**20 Dow St. - Permit 2017-01951**

I have completed my initial review of your application and I need more information before I can sign off on the permit for zoning.

FOOTINGS

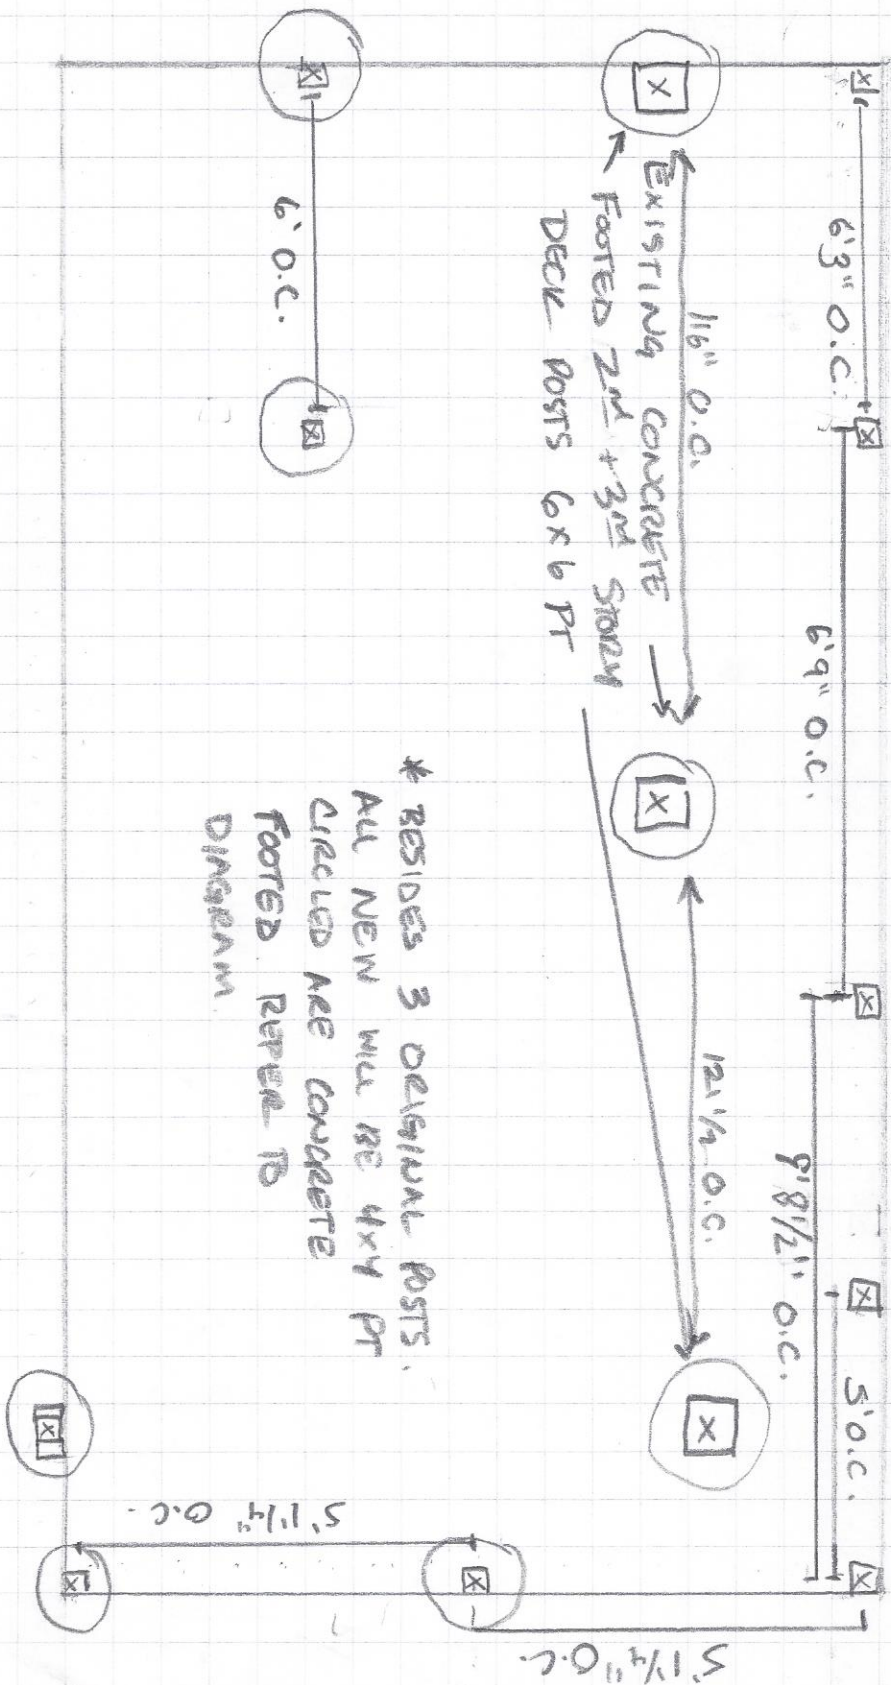
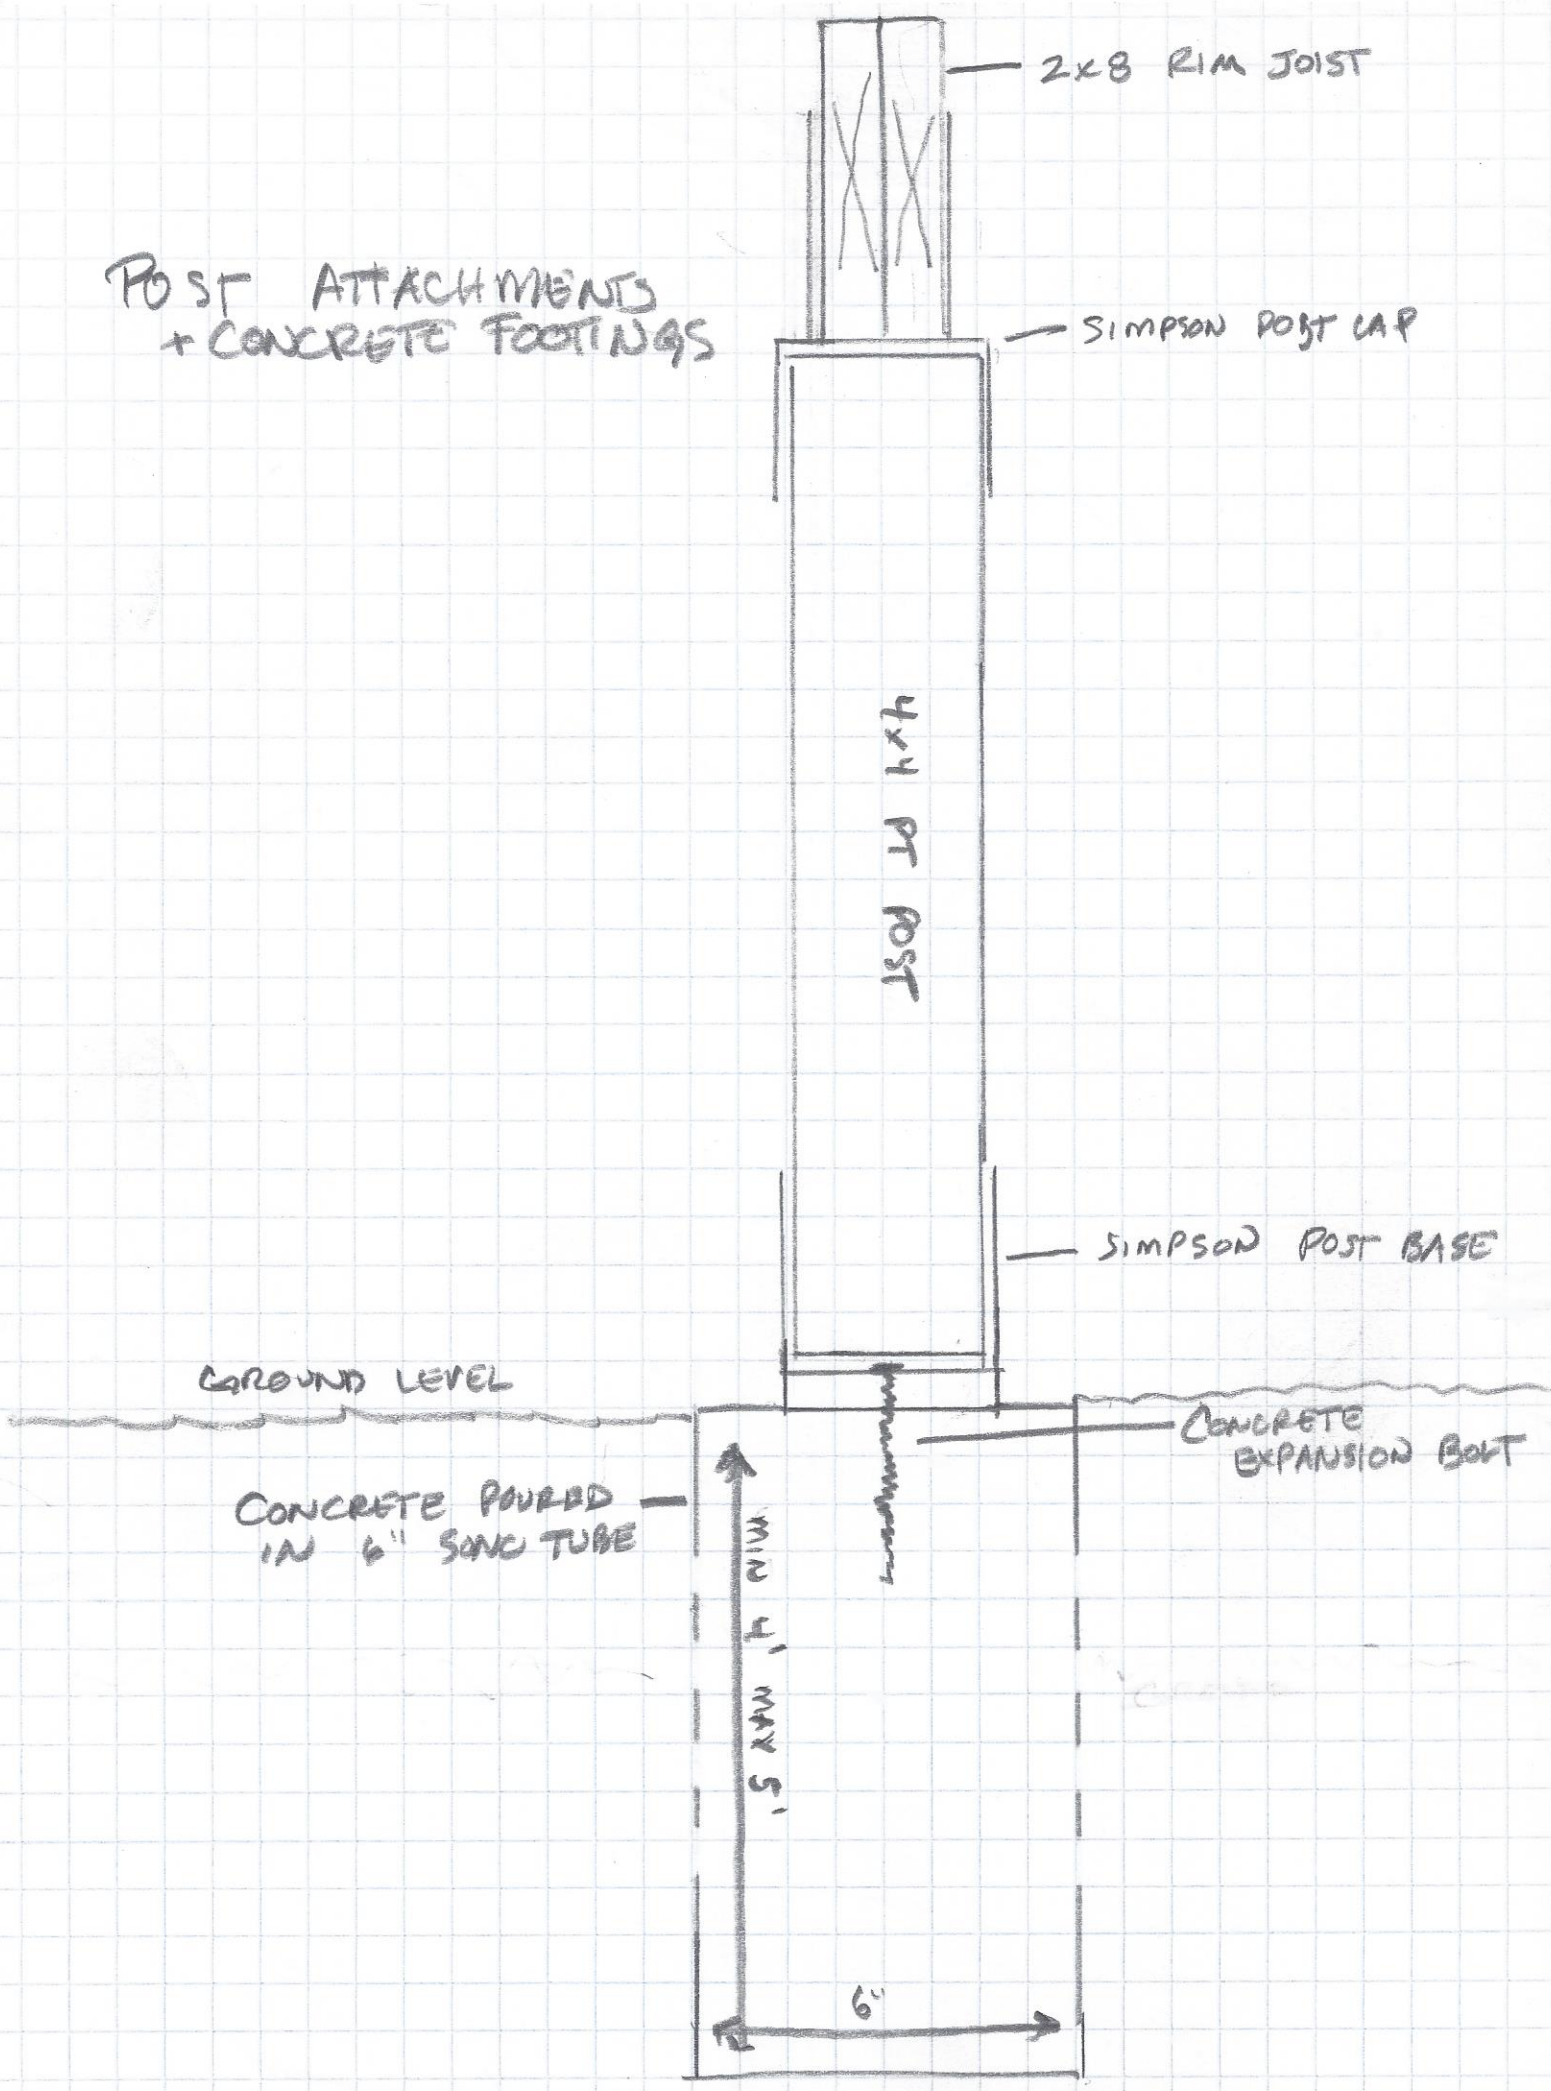
You need to rebuild the deck as it was shown on the Mortgage Loan Inspection Plan. Please submit revised plans for the deck footing detail and the deck framing plan. Also you said "that when the deck is built it will be built within our property". Can you please show on the deck framing plan how you are going to accomplish this? It appears that the deck cannot be an exact rectangle based on the survey.

DECK FRAMING PLAN

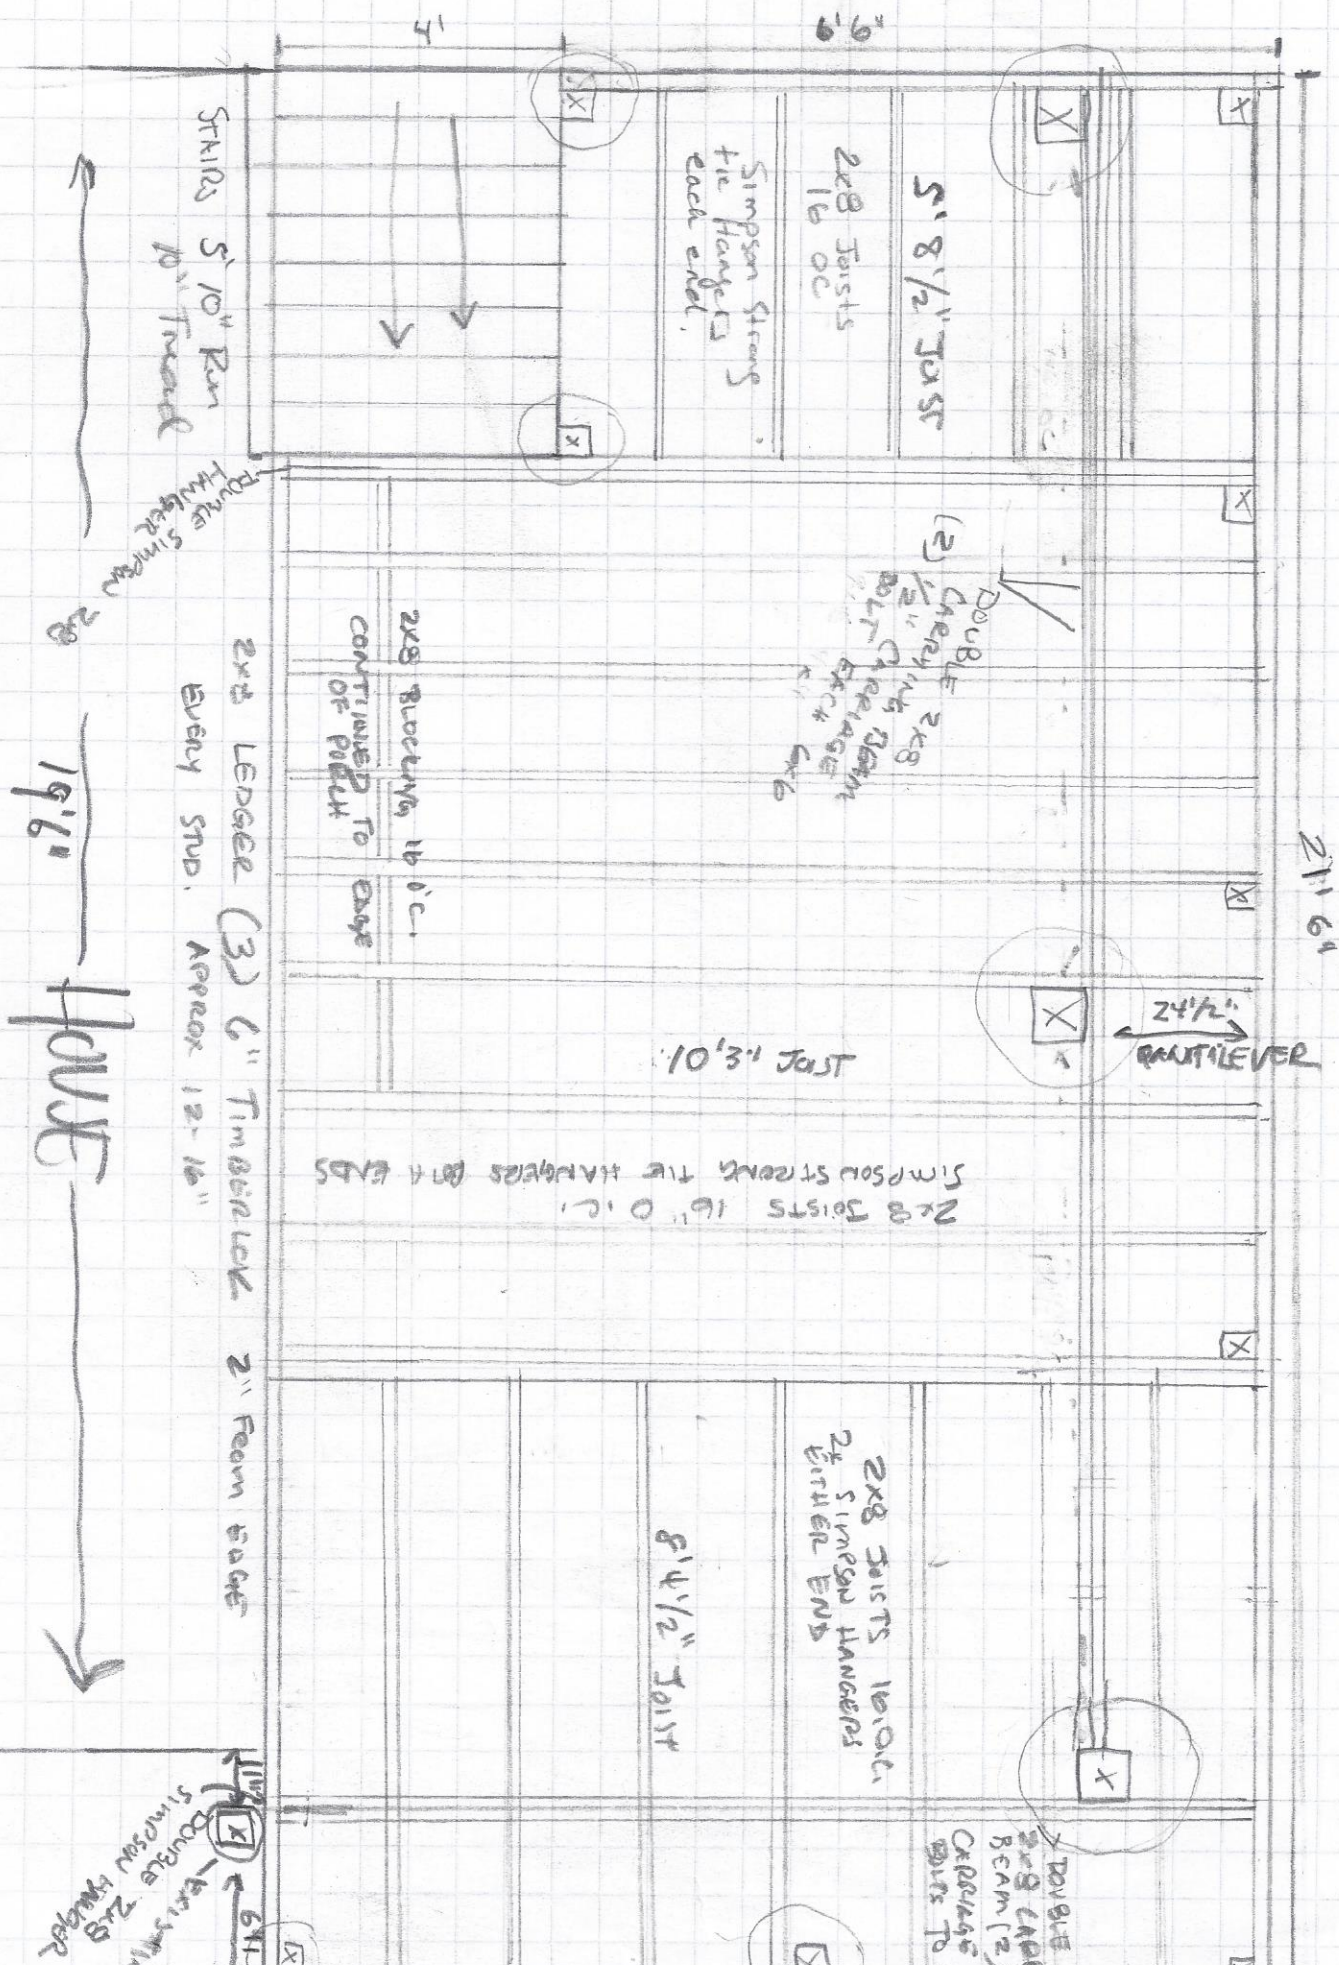
You said that you're replacing the existing first floor deck. Can you submit a plan that shows the exact dimensions of the existing deck including the stairs to grade? Also I'm confused about the "Land Survey With Set Back" that you submitted. The survey shows the existing deck as in line with the rear of the building with the small bottom right corner encroaching onto the neighbor's property. I don't understand what the blue lines represent.

that was approved by the Zoning Board of Appeals on 12/11/1997 shows the footprint of the first floor deck. The footprint on this plan scales at 7.25' deep and 16.75' long with a set of stairs 3.75' wide by 6.5' long extending off the left side of it towards the left rear corner of the building. The deck did not extend the full length of the building. It extended three feet off the right rear corner of the building. This is confirmed by a street view picture from Google Earth that shows the first floor deck from Horton Place (attached). There is no evidence to show that that the first floor deck extended to the rear property line or the full length of the building as shown by the blue lines added to the survey and the dimensions on the deck framing detail plan.

# MORTGAGE LOAN INSPECTION

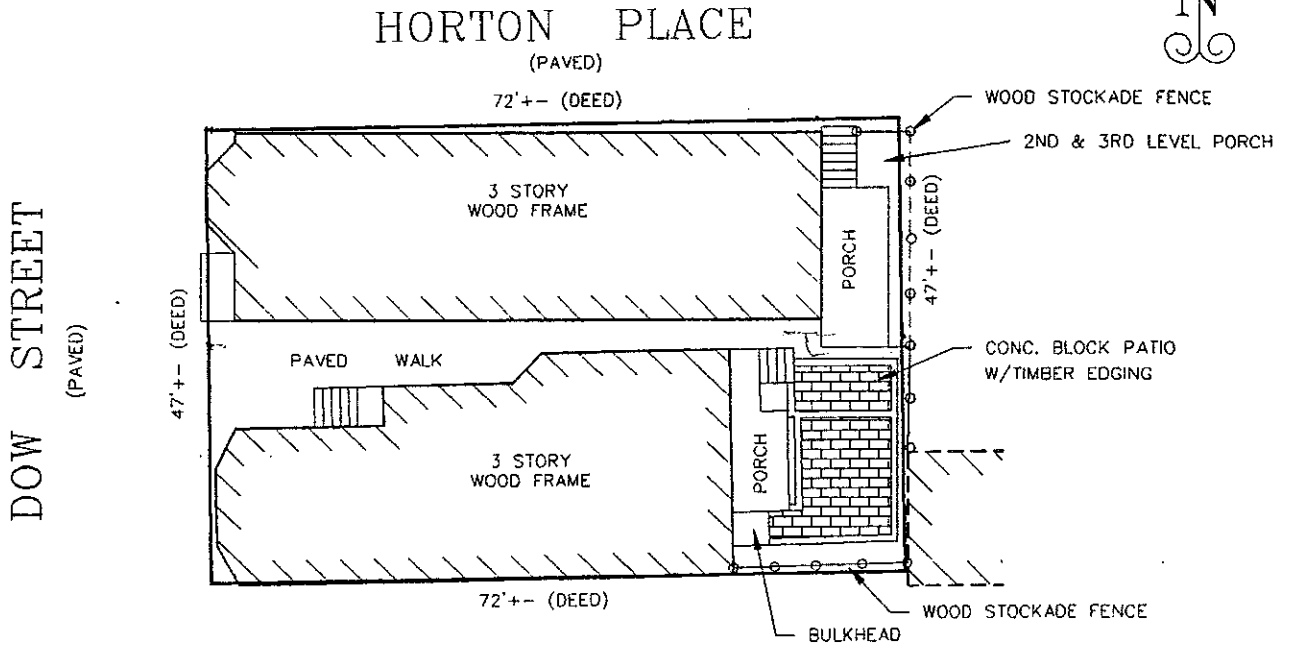
It appears from other evidence that the footprint of the first floor porch that you are replacing is smaller than the upper floor porches. The Mortgage Loan Inspection Plan (attached) submitted as part of the Miscellaneous Appeal Application
